Application Ref: H14-1288-25

Proposal: **Conversion of agricultural building to a residential dwelling**

Location: **Nunnerley House Farm, Leaveslake Drove, West Pinchbeck, Spalding PE11 3QJ**

Site Location Plan

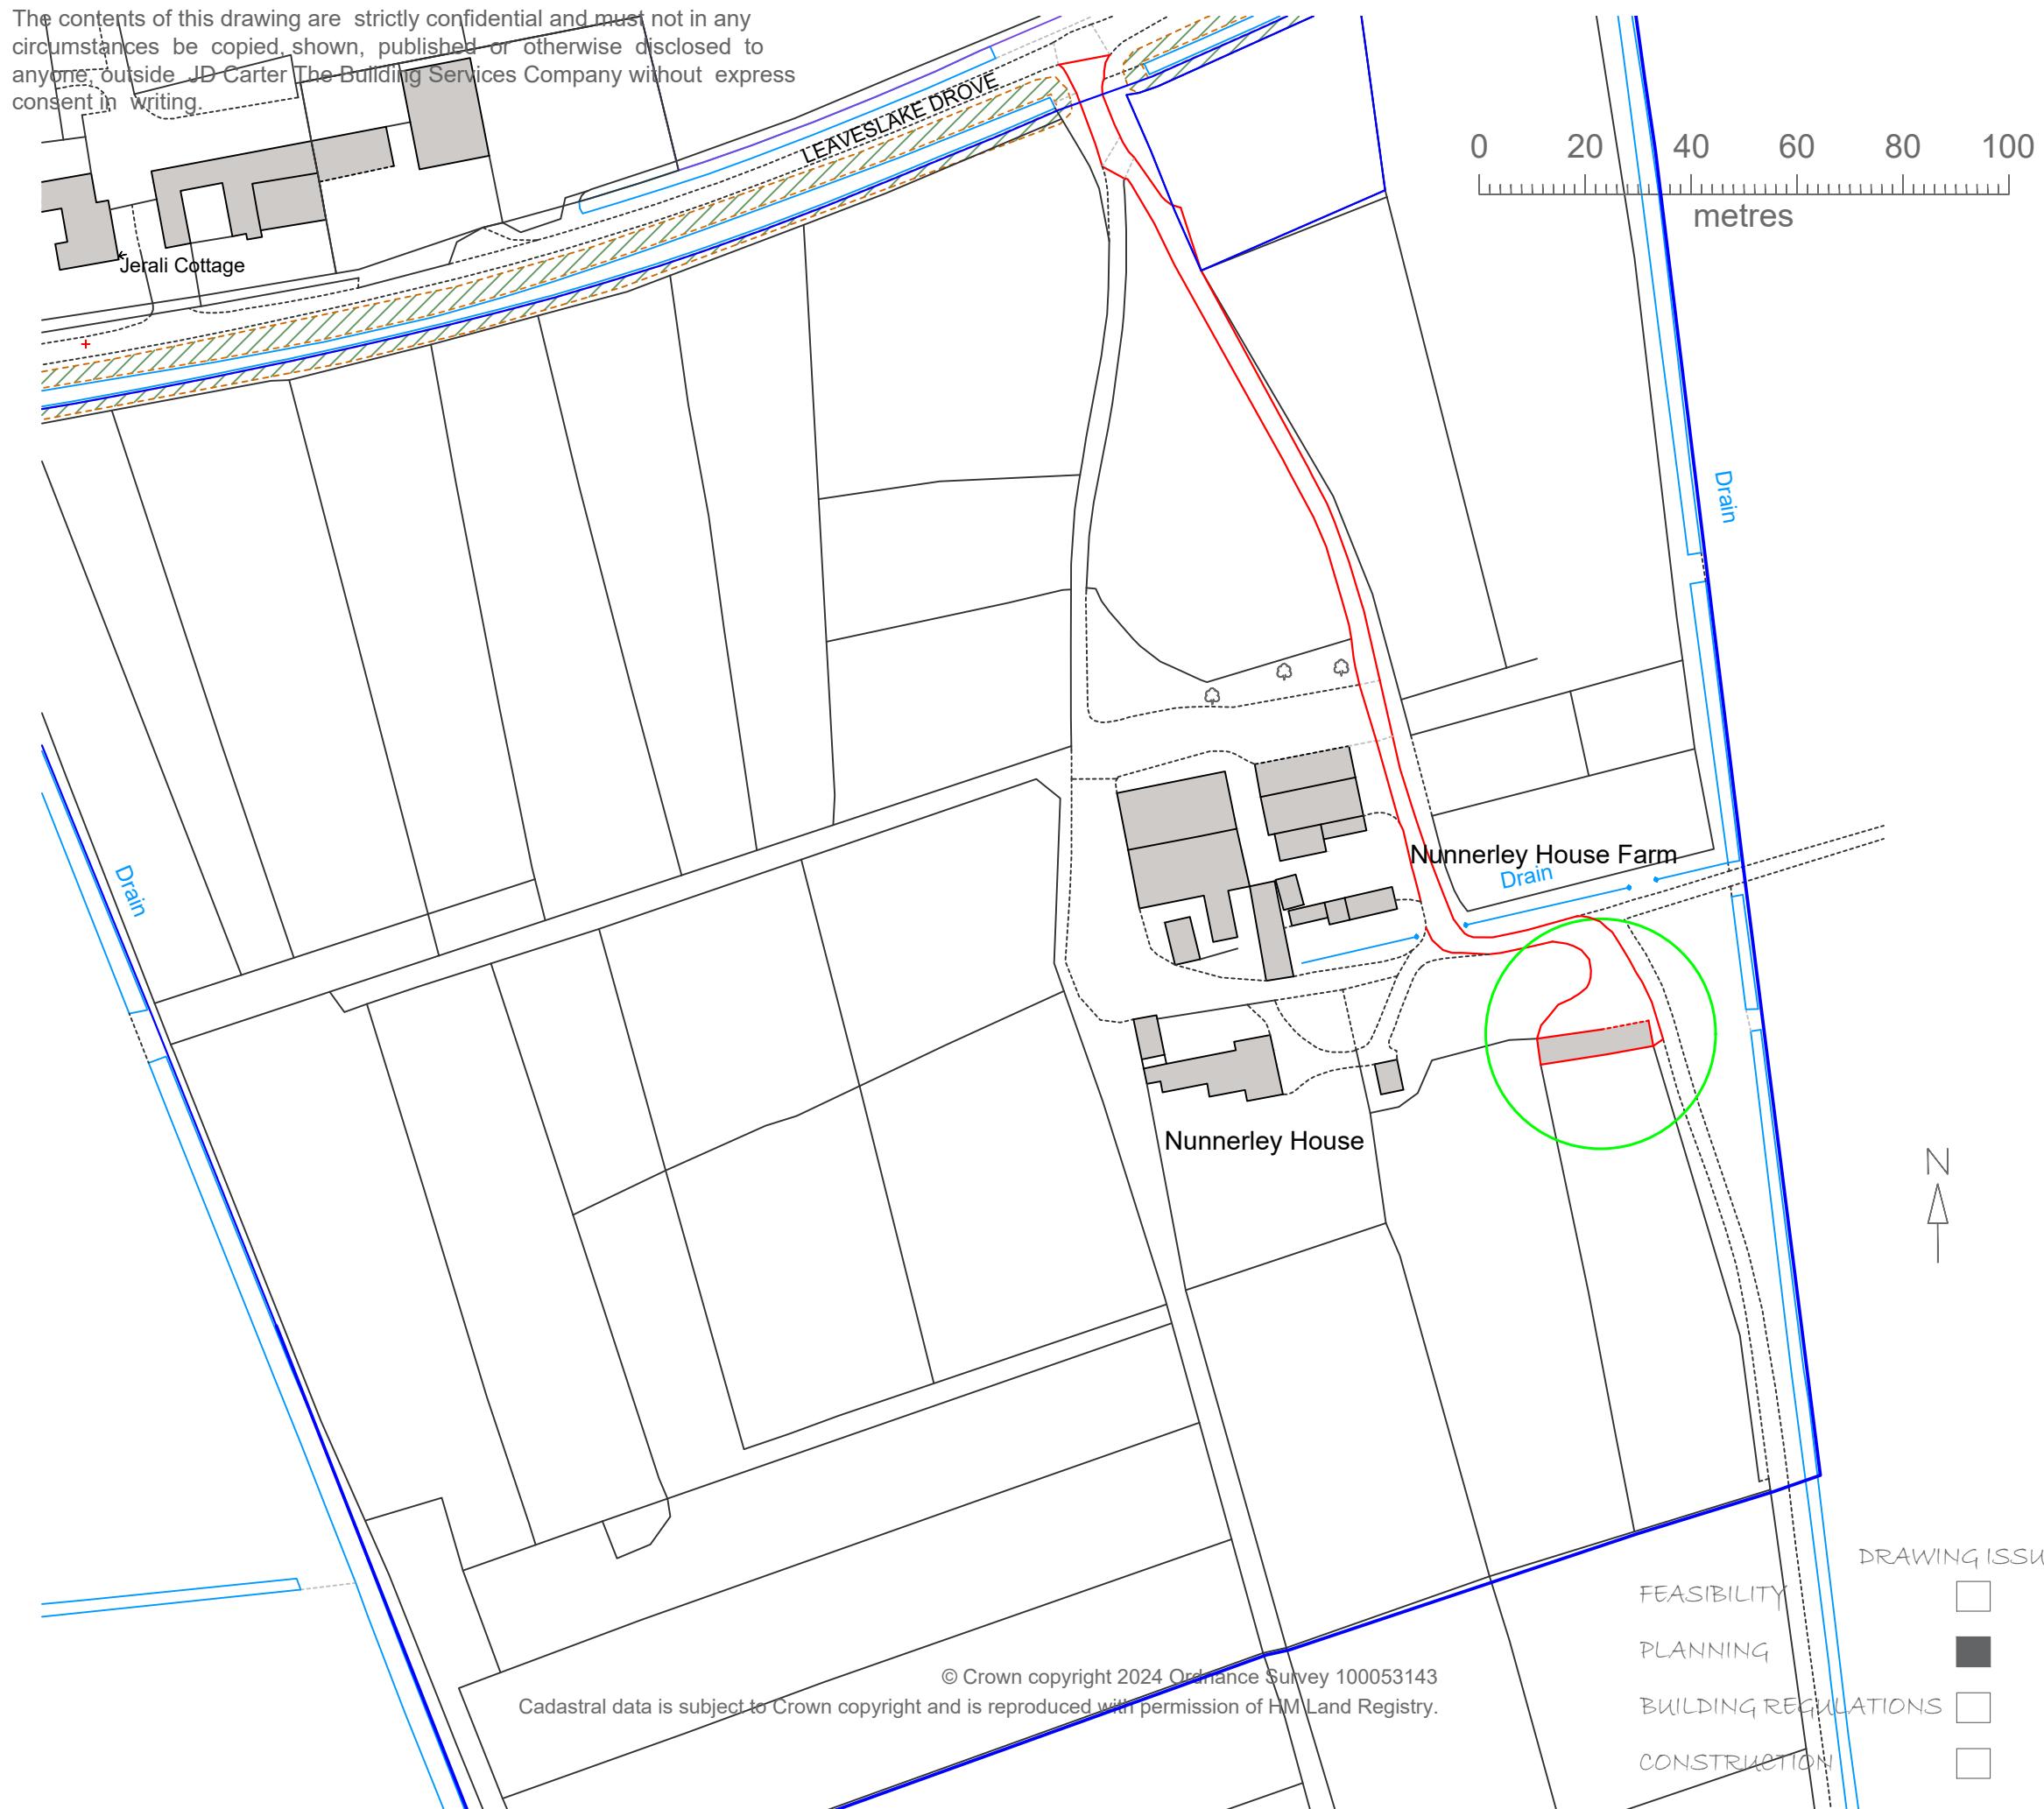
The width of the access and private drive needs to be detailed. A shared private drive should measure 4.1m wide for the first 10m, and 3.7m wide thereafter
